**From:** Hunyadi - DNR, John  
**Sent:** Tuesday, October 08, 2019 1:06 PM  
**To:** Charles Cothern  
**Cc:** Cothern, Charles; Durham, Charlene  
**Subject:** Re: The Gardens at North Carefree Detention Pond Breach Analysis

# Memorandum

Date: October 3, 2019

Subject: The Gardens at North Carefree Detention Pond  
Embankment Hazard Classification

GARDENS AT NORTH CAREFREE SOUTH WQ POND	
Designer: CD	Structure Numbers
Detailer: MB	
Sheet Subset:

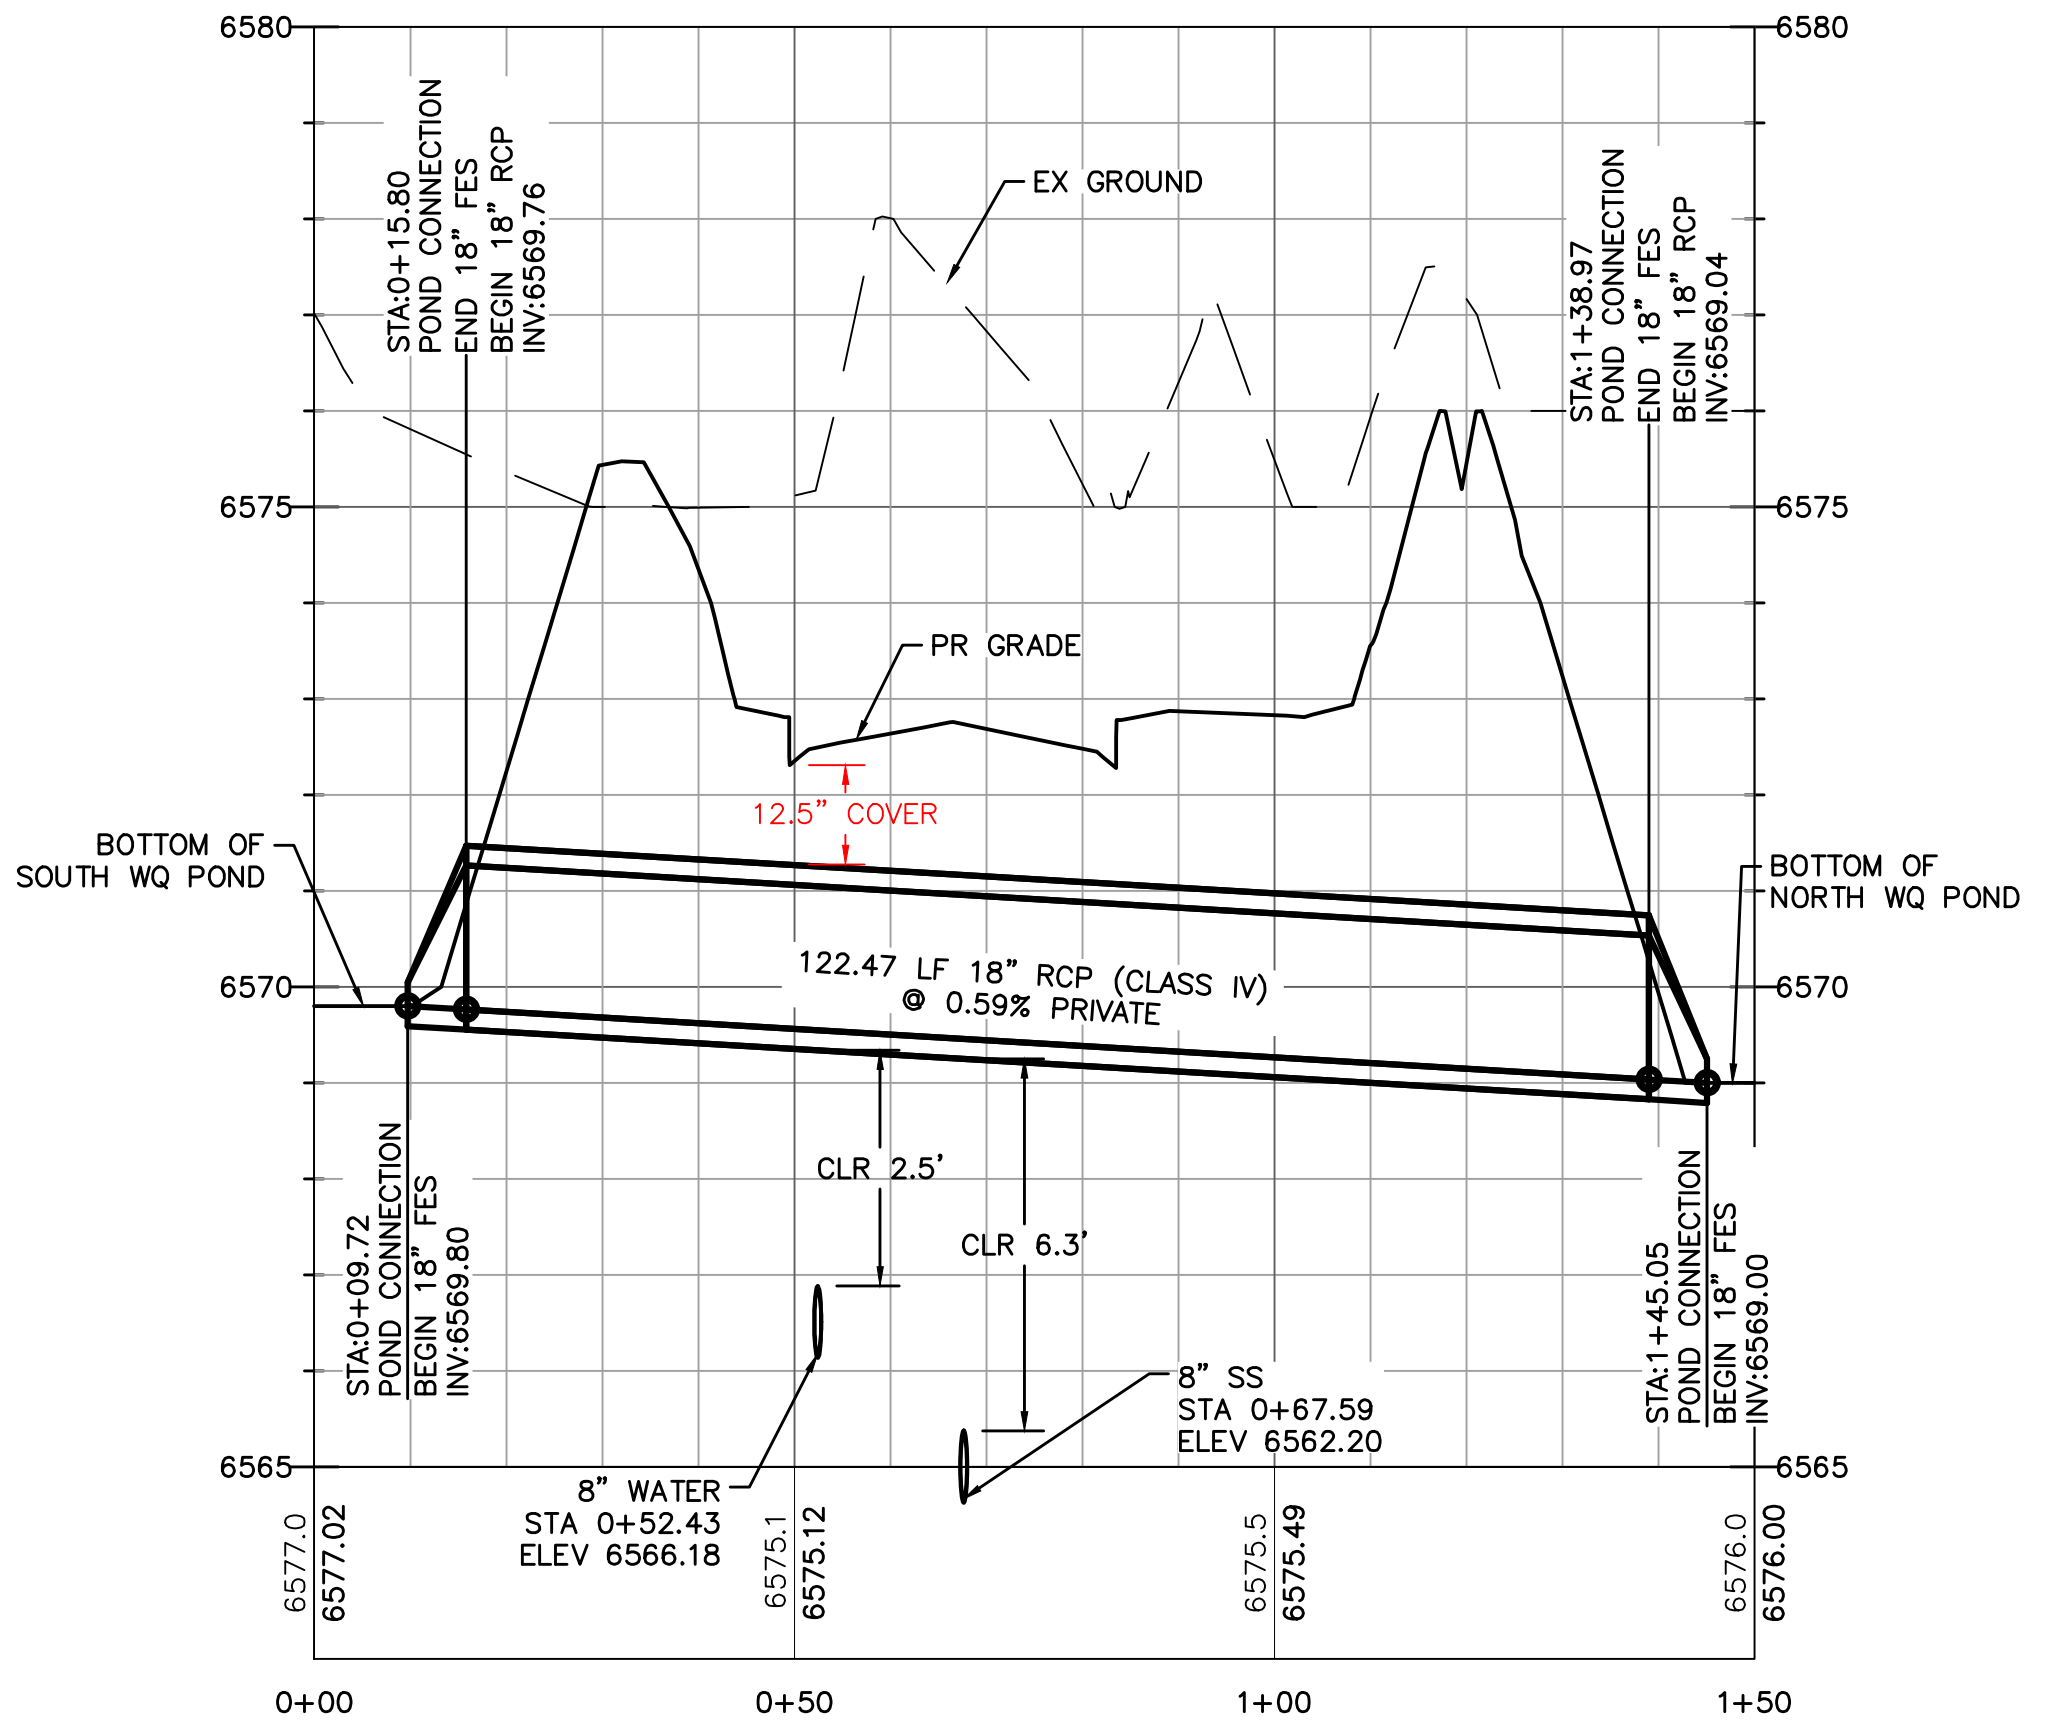
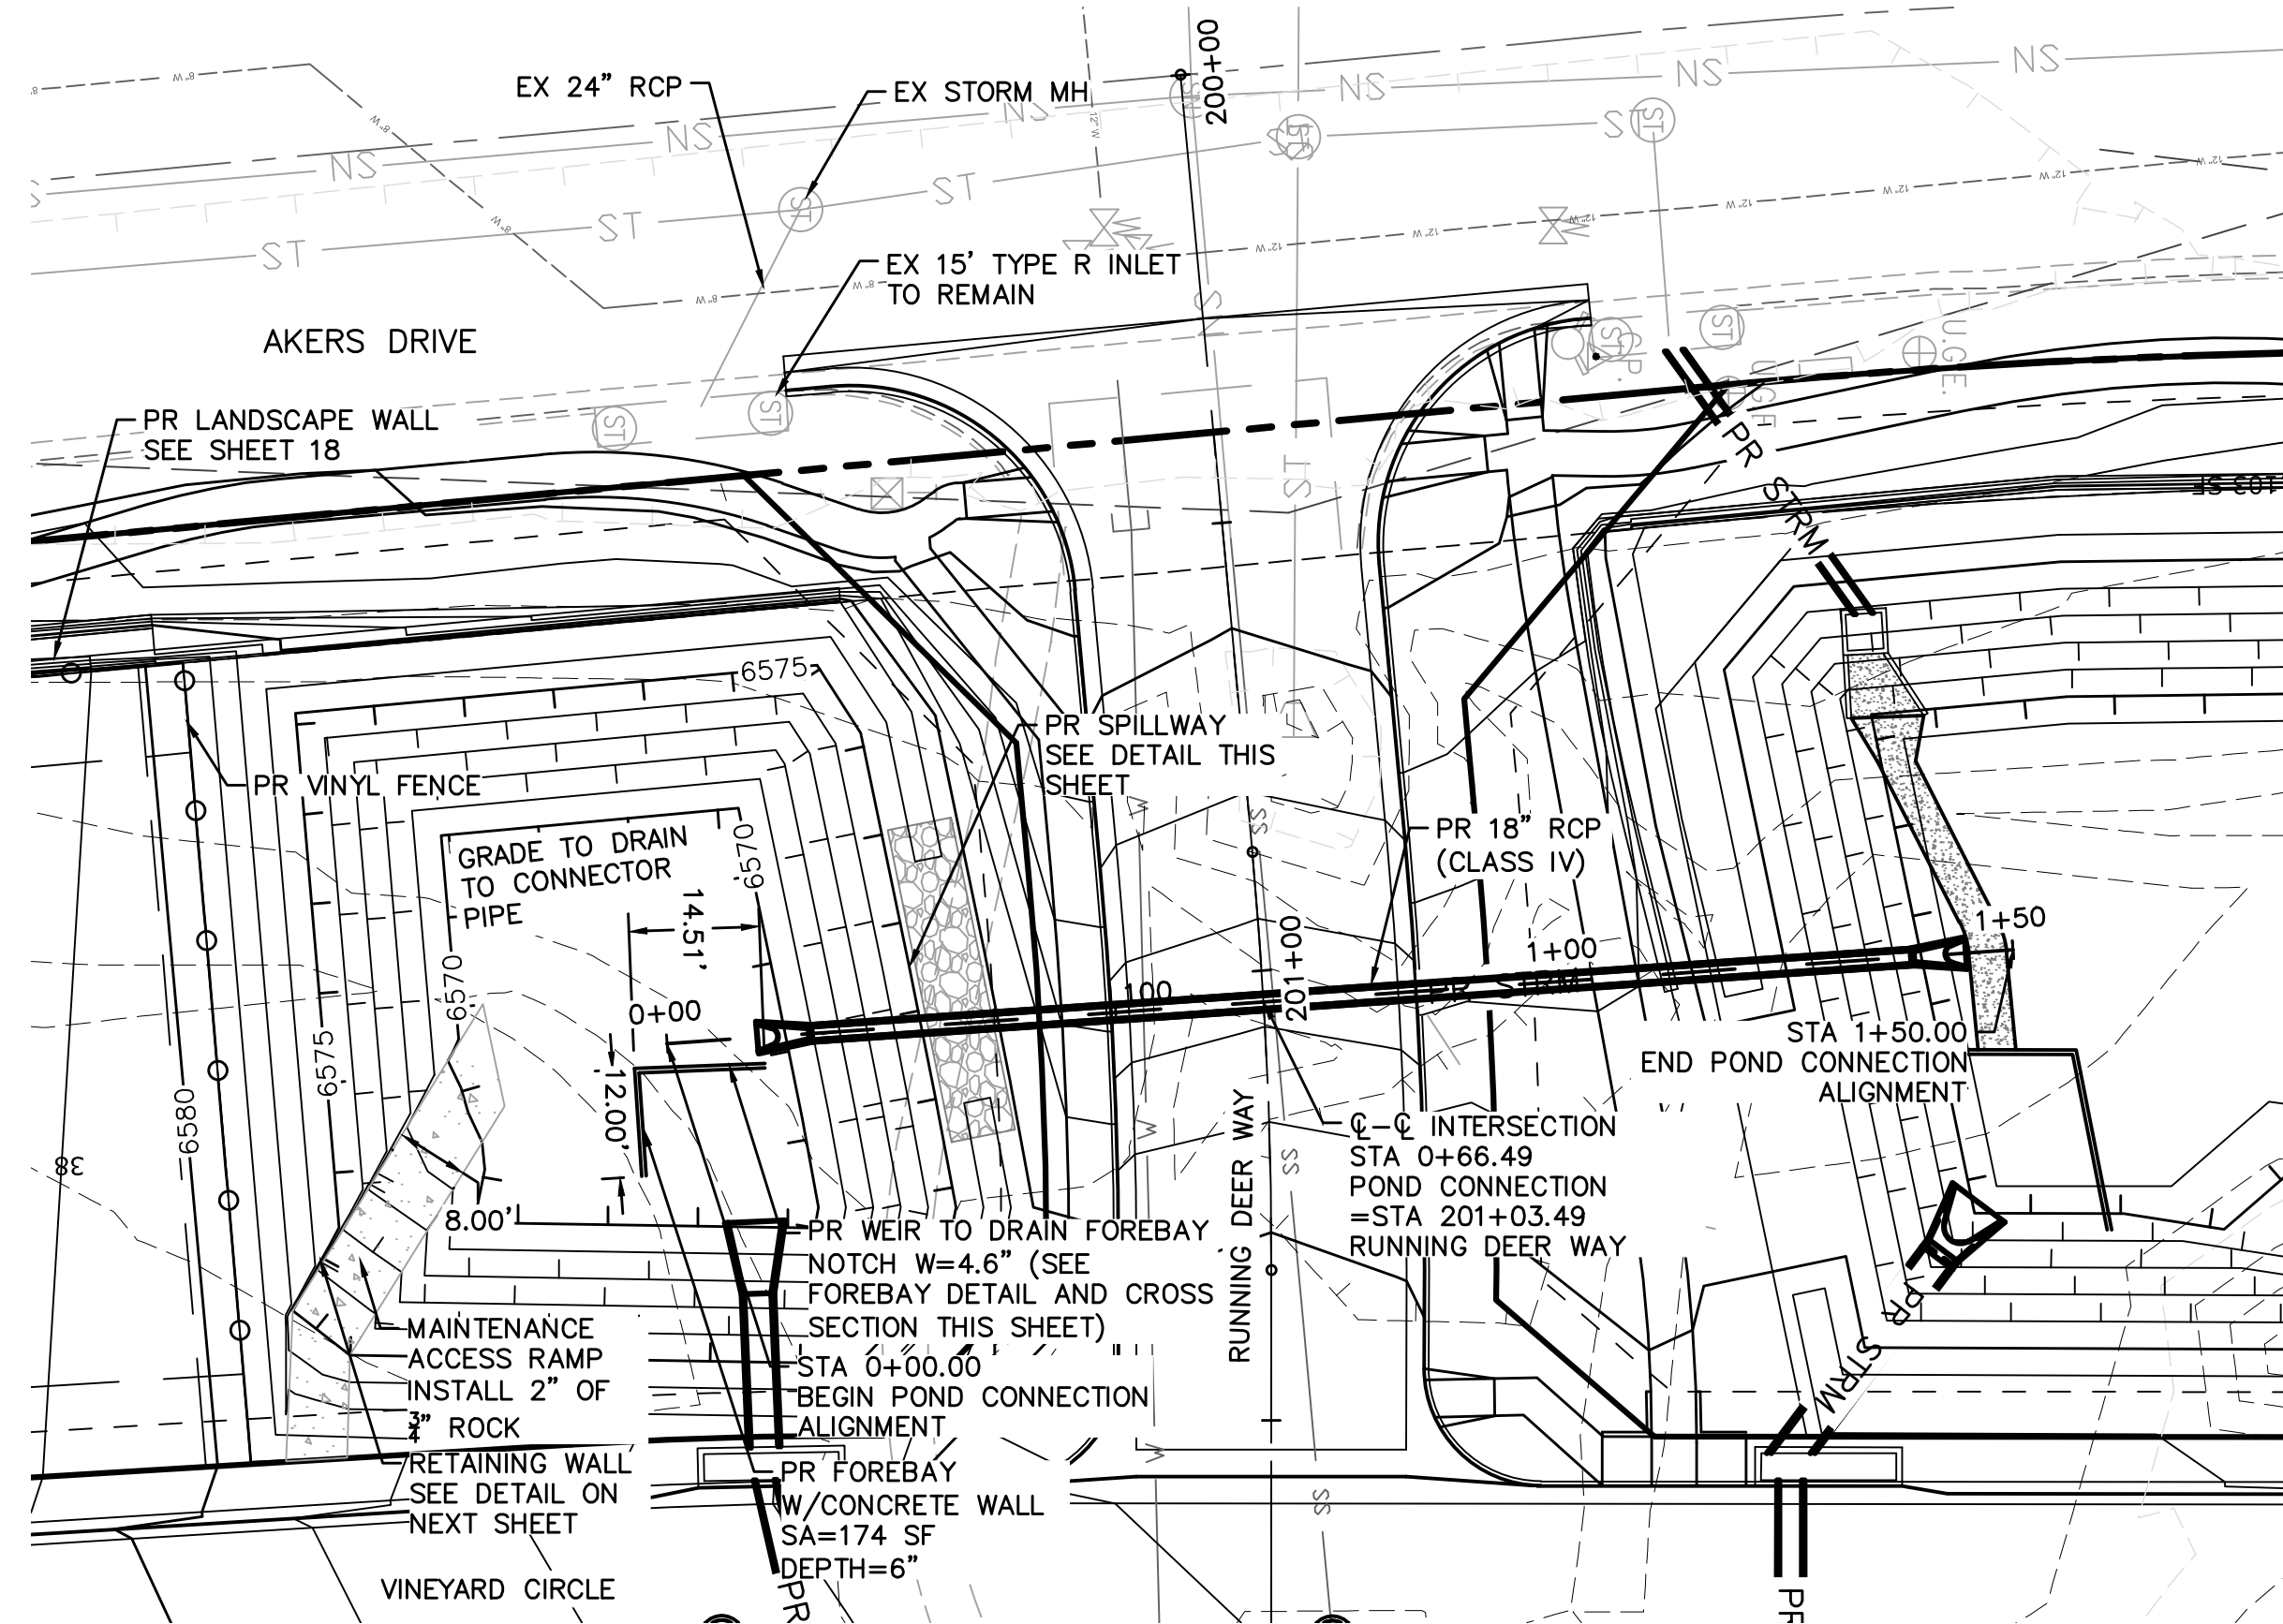
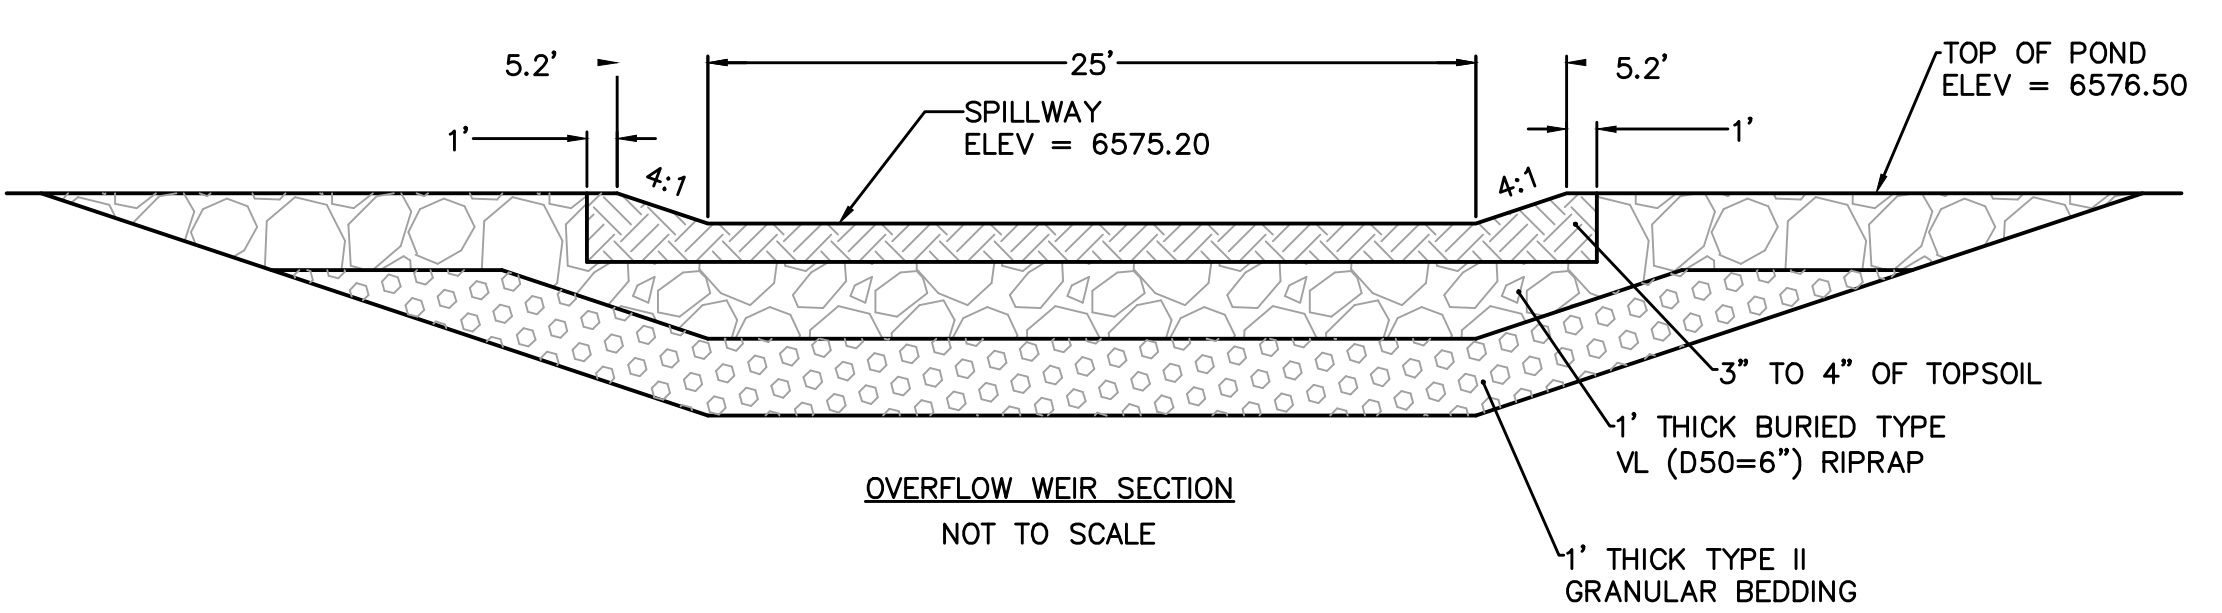
Thank you for the memorandum and analysis. I am in agreement with your conclusions regarding the hazard classification of these structures and will look forward to the NOI forms submitted to our office when you get to that point.
